**Application Number SSI 7485****WestConnex M4-M5 Link – Modification 2 The Crescent overpass**

**Martin O'Dea**  
**Lilyfield**

Figure 4-7 Elevation: Indicative view of the shared user path bridge

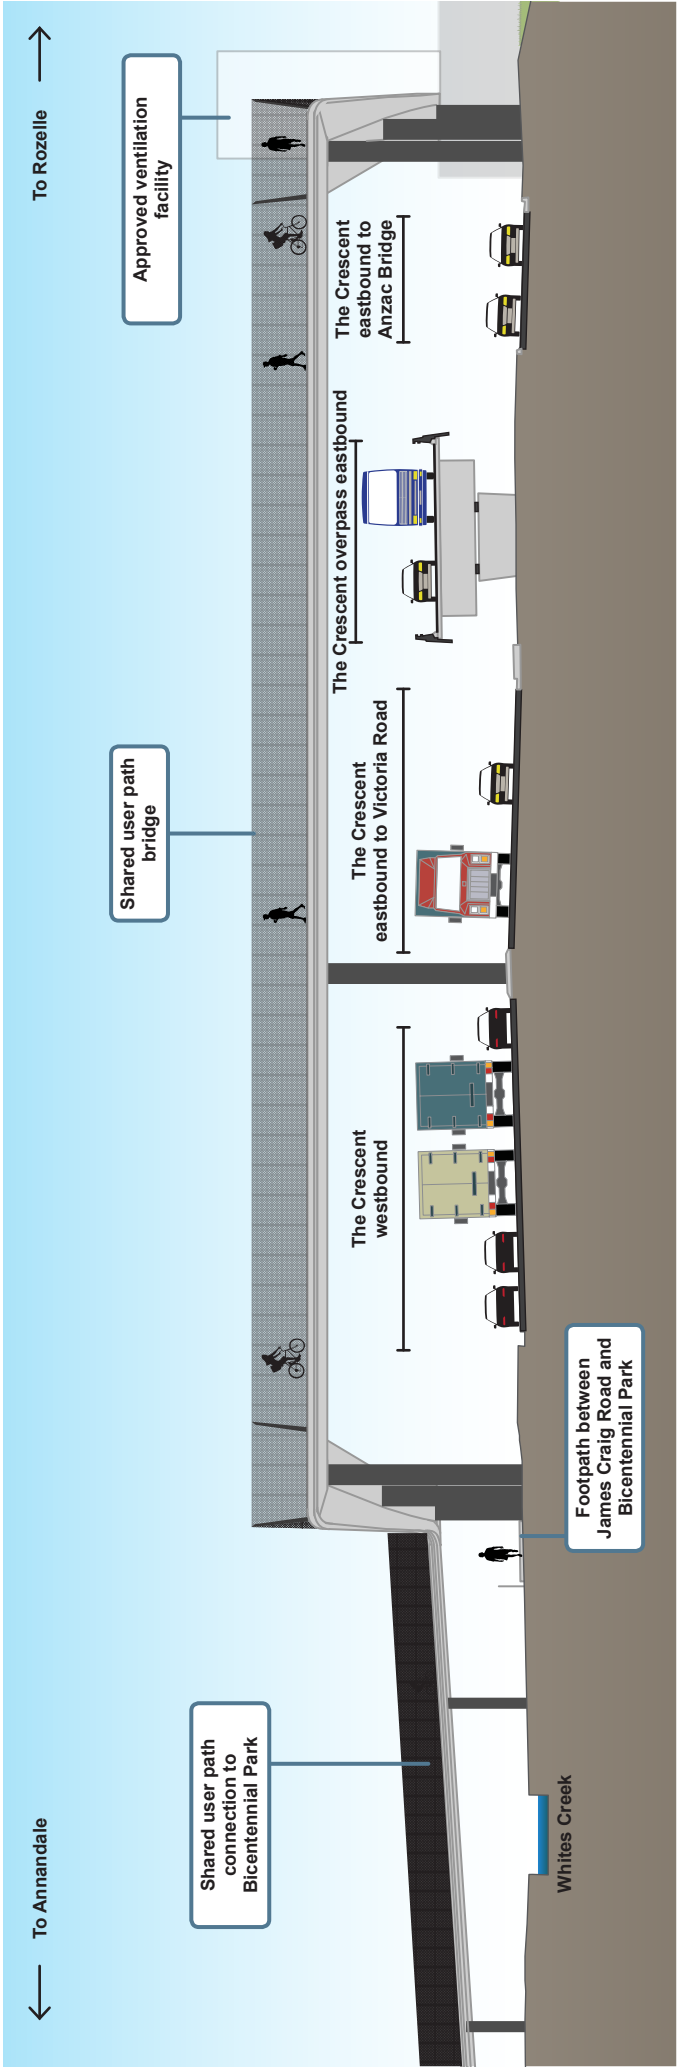
To overcome this lack of a direct link, the modification has added a second pedestrian bridge. As this has to get over the new vehicle overpass, it is another three metres higher than a direct connection. This is adding about 120m length to the walkway to meet accessible grades. An undergrounded tunnel connection would avoid the need for this second bridge.
